**KIRKLEES METROPOLITAN COUNCIL  
INVESTMENT & REGENERATION SERVICE**

**DELEGATED DECISION TO DETERMINE PLANNING APPLICATIONS**

Reference No:	<b>2025/62/92516/W</b>
Site Address:	57, Birch Road, Berry Brow, Huddersfield, HD4 7LR
Description:	Erection of single storey rear extension
Recommending Officer:	Joshua Merriman

## **Officer Report – 2025/92516**

Drawing Title: **PROPOSED FLOOR PLANS,
ELEVATIONS & SITE LAYOUT**

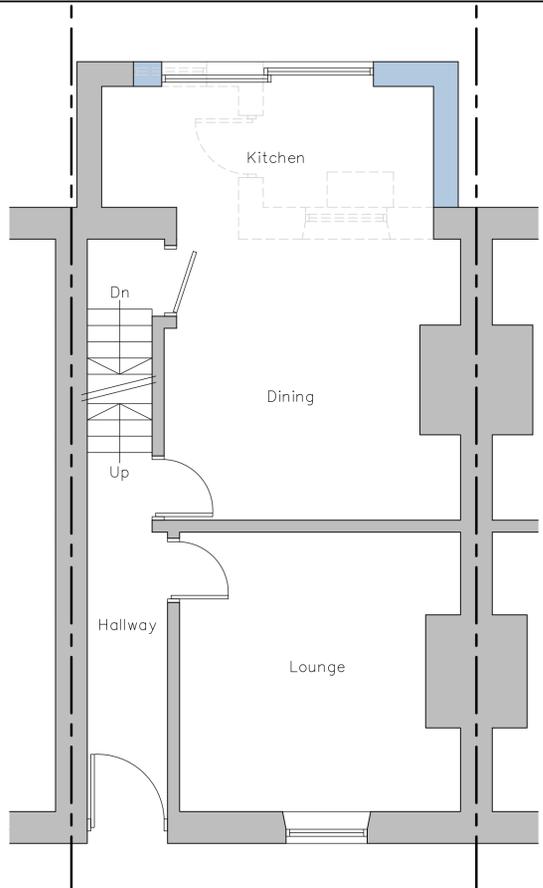
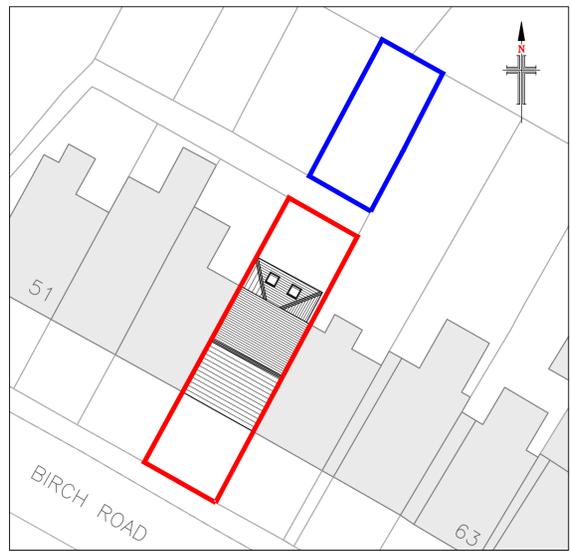
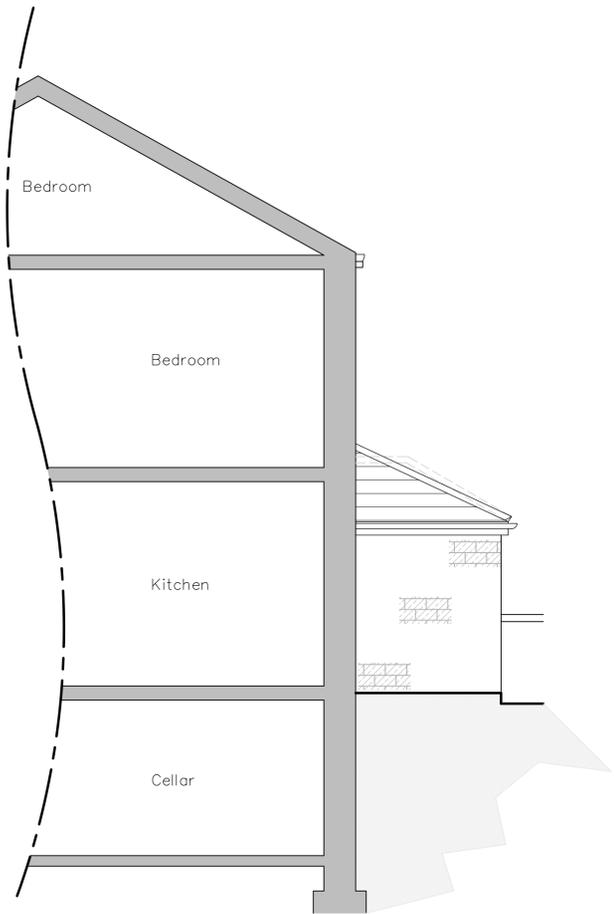
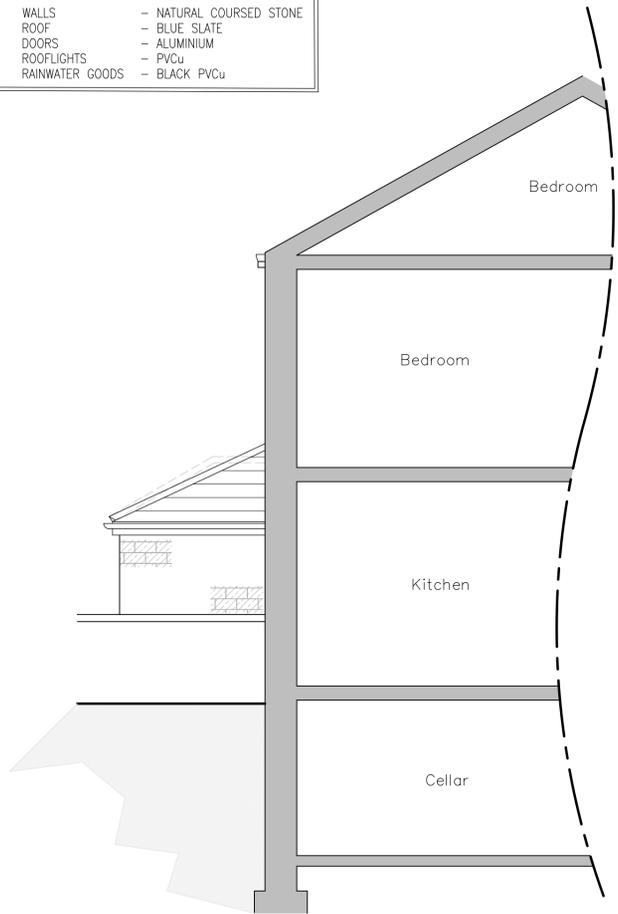
As the application property is terraced, the proposed rear extension will be entirely set behind the original building, not projecting beyond the sides, and

not visible from the front of the property. Furthermore, the extension is considered to be subservient to the host property, remaining in keeping with the scale and style of the original house, thus having no significant impact upon visual amenity.

The proposed rear extension does not exceed a projection of 3m from the rear elevation of the original building; however, the proposal is located within 1m of the property boundary. Despite this breach, due to the design of the extension sloping away from neighbouring dwellings, and the acceptable projection distance of the extension, it is considered that there will be no significant impacts upon neighbouring dwellings with regard to residential amenity, including overbearing, overshadowing, privacy, light, and outlook.

2. The external walls and roofing materials of the extension hereby approved shall in all respects match those used in the construction of the existing building.
